25 June 2026

Our Ref: R/2025/6/B
File No: 2026/364040
Your Ref: SSD-80211463

Advice on RTS – Mixed use development with in-fill affordable housing – 164-194 William Street, Woolloomooloo – SSD-80211463

Figure 7: Pedestrian wind speed measurement locations with comfort/safety ratings – SSDA Scheme (Configuration C)

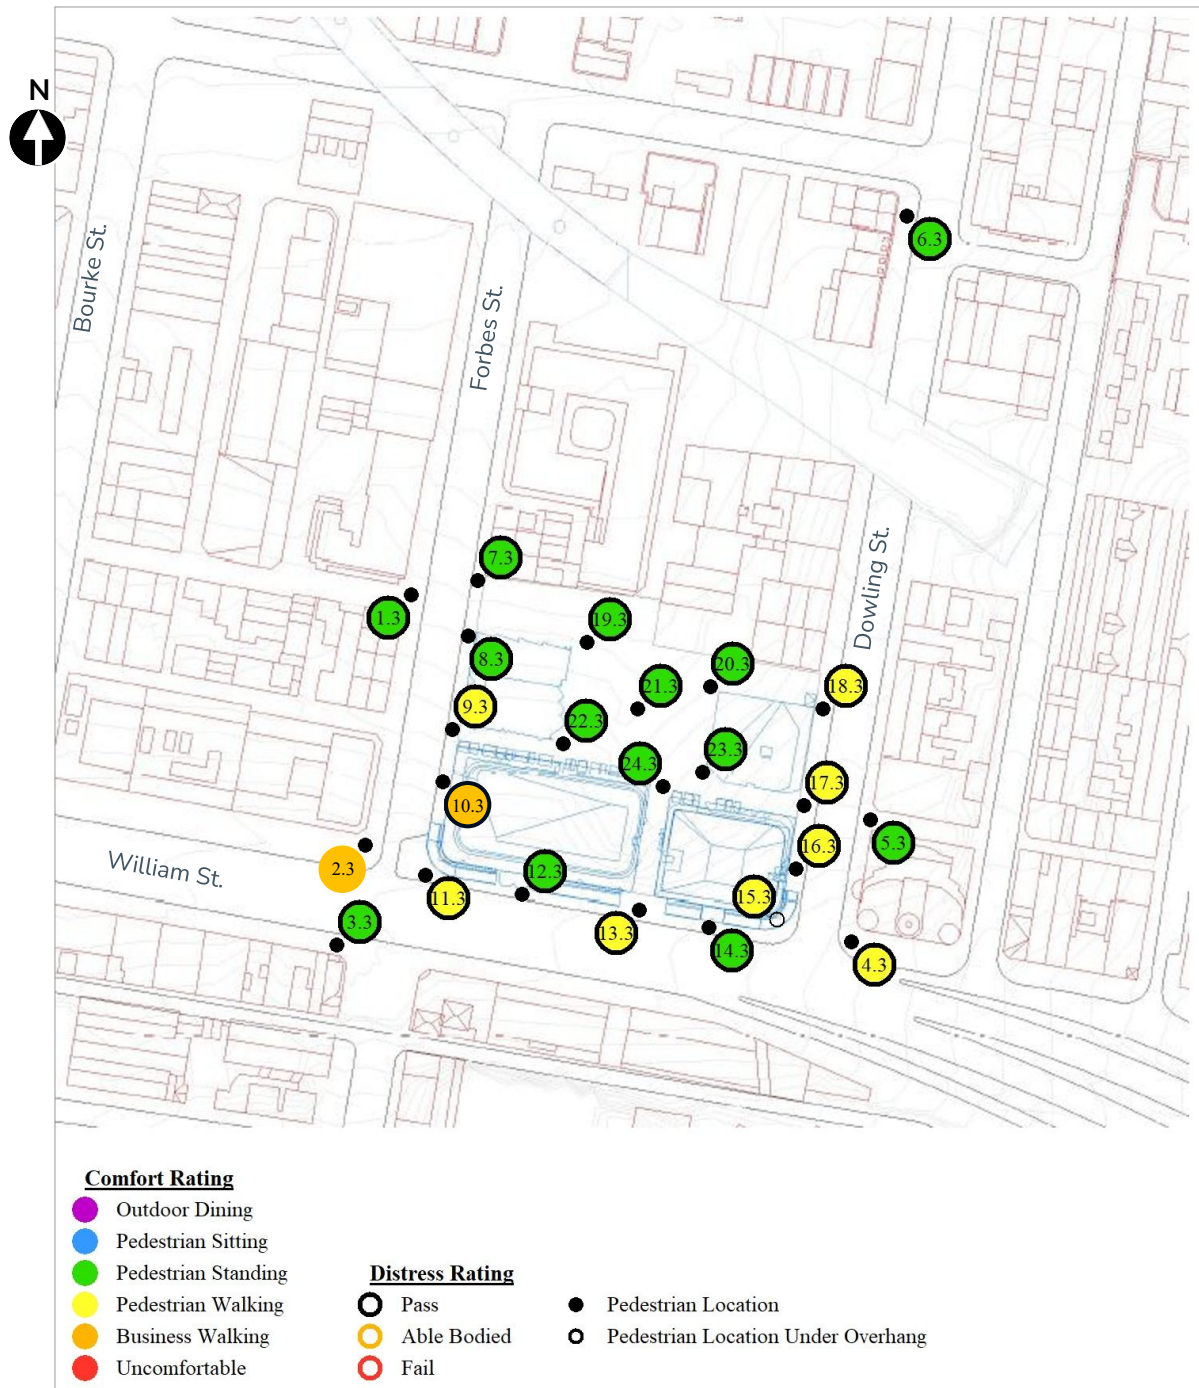
- Solar access analysis remains inadequate, as discussed above.
- The Wind Report does not demonstrate an acceptable wind outcome. Locations 19, 20, 22, 23, rooftop communal open space and private open space should achieve sitting criteria, and locations 13 and 16 should achieve standing criteria. Any mitigation measures required to create safe and comfortable spaces must be included in the relevant drawings. It is unacceptable to delay the delivery of these measures to the future residents.

Figure 10: General Arrangement Plan – Level 9 – William Street West Building

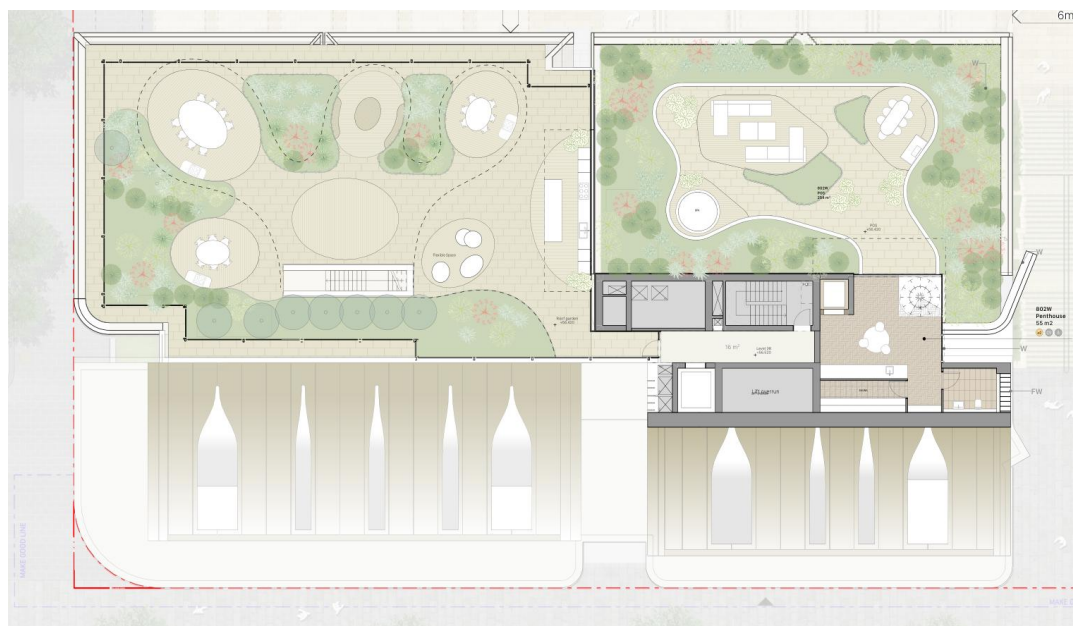
- Shade structures and canopy planting is required to be correctly shown on all architectural plans. This will provide shade and wind protection to and ensure the rooftop offers residents a high amenity space.

## Attachment 3 - Deep Soil Zone and Laneway Plan

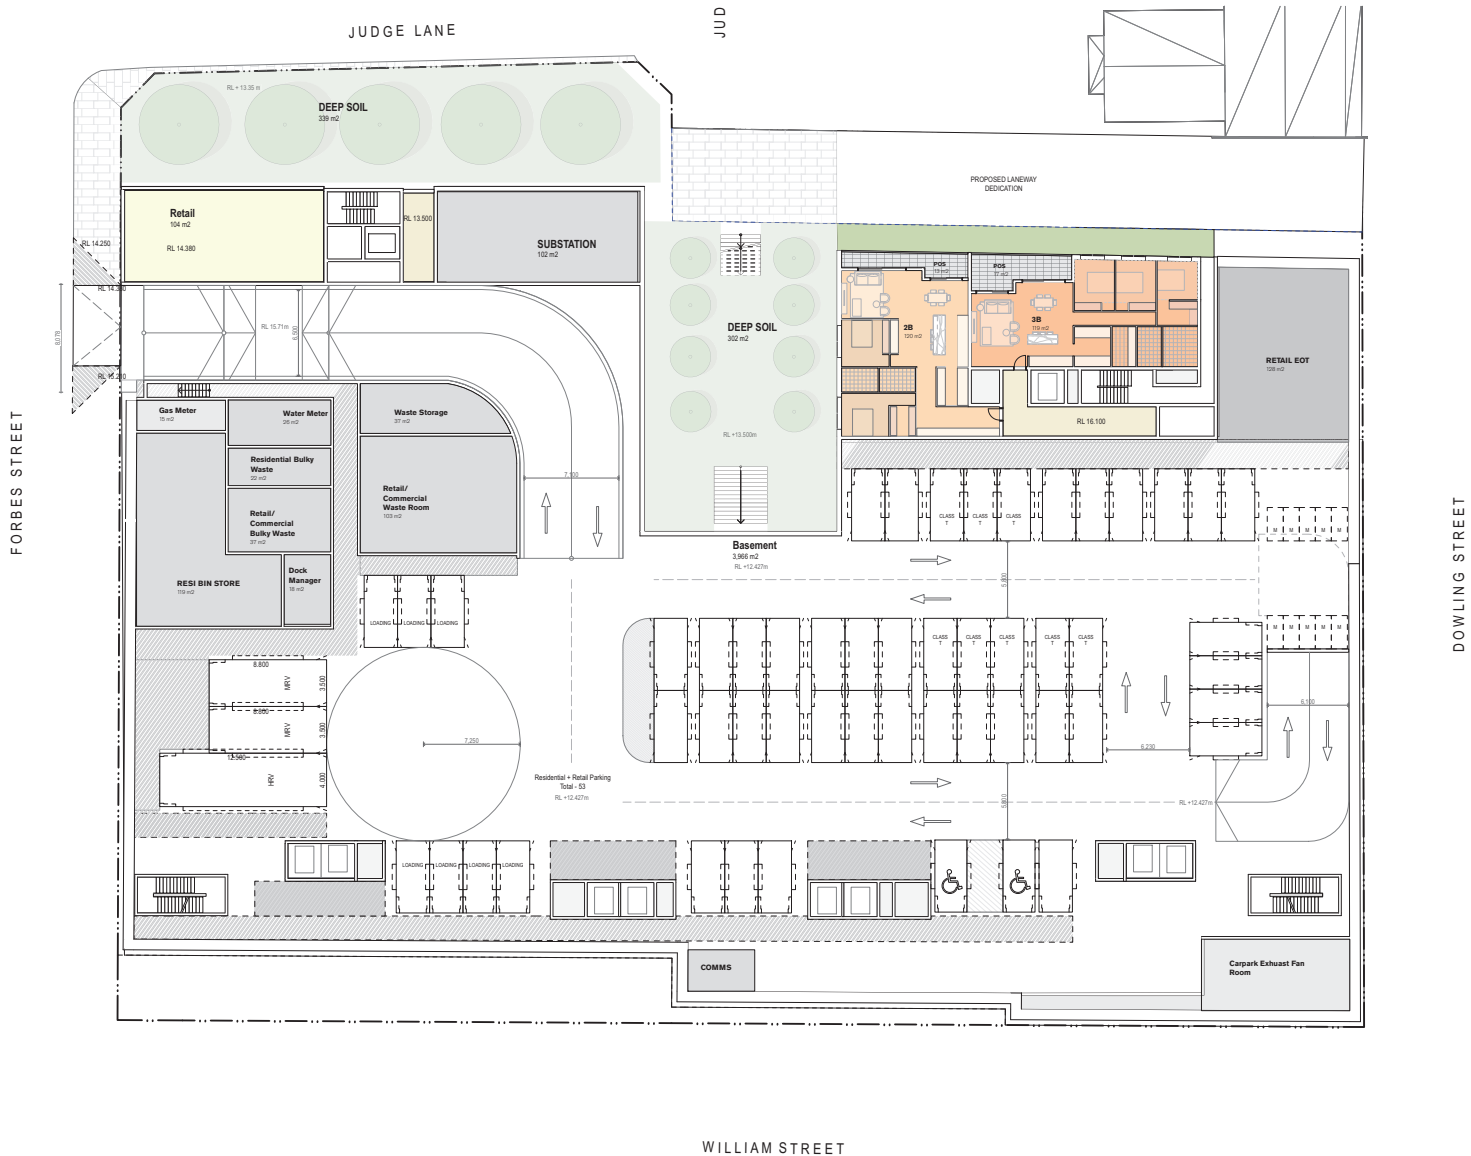
- Design of the nominated deep soil area remains unchanged, and it is still significantly encumbered by structures. The provided arborist's report is inadequate and does not meet the required standard.

Figure 1: Flood ingress points in relation to flood depths and levels in the 1% AEP CC2030 event

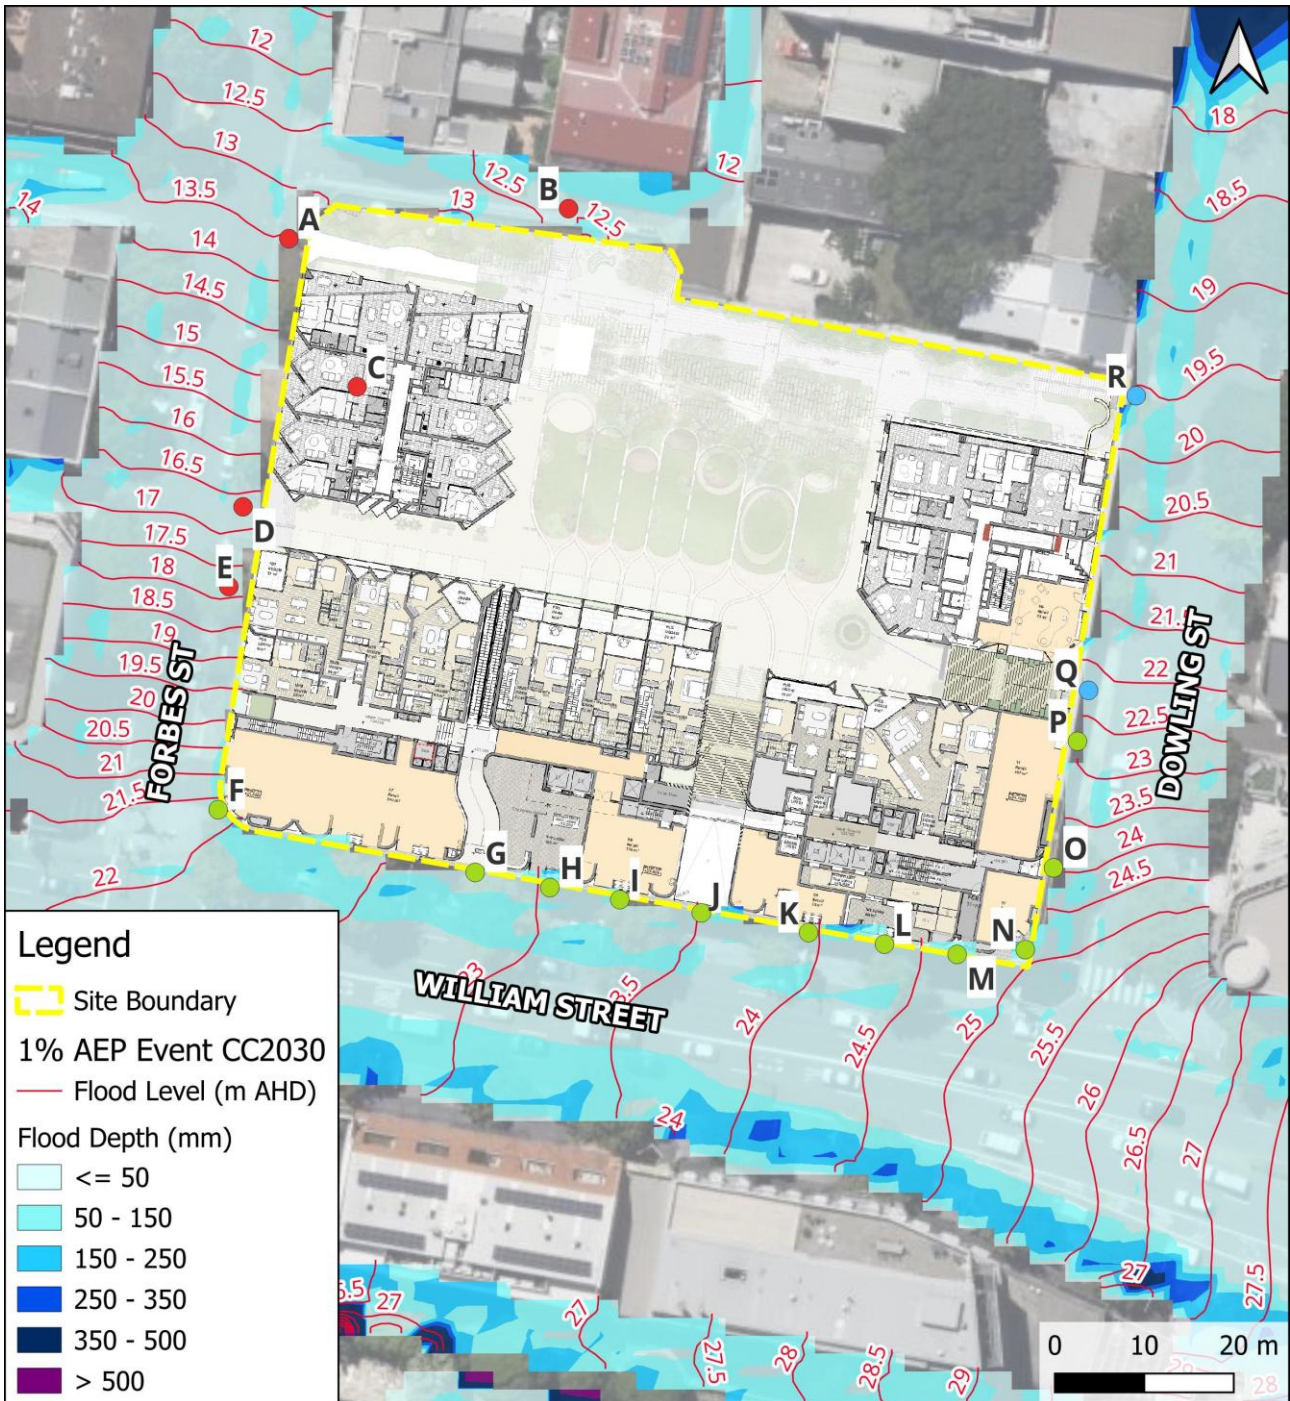
- Flooding issues raised in the City's EIS submission remain unresolved and must be resolved prior to any approval.
- An updated Integrated Water Management Plan must be submitted for assessment.
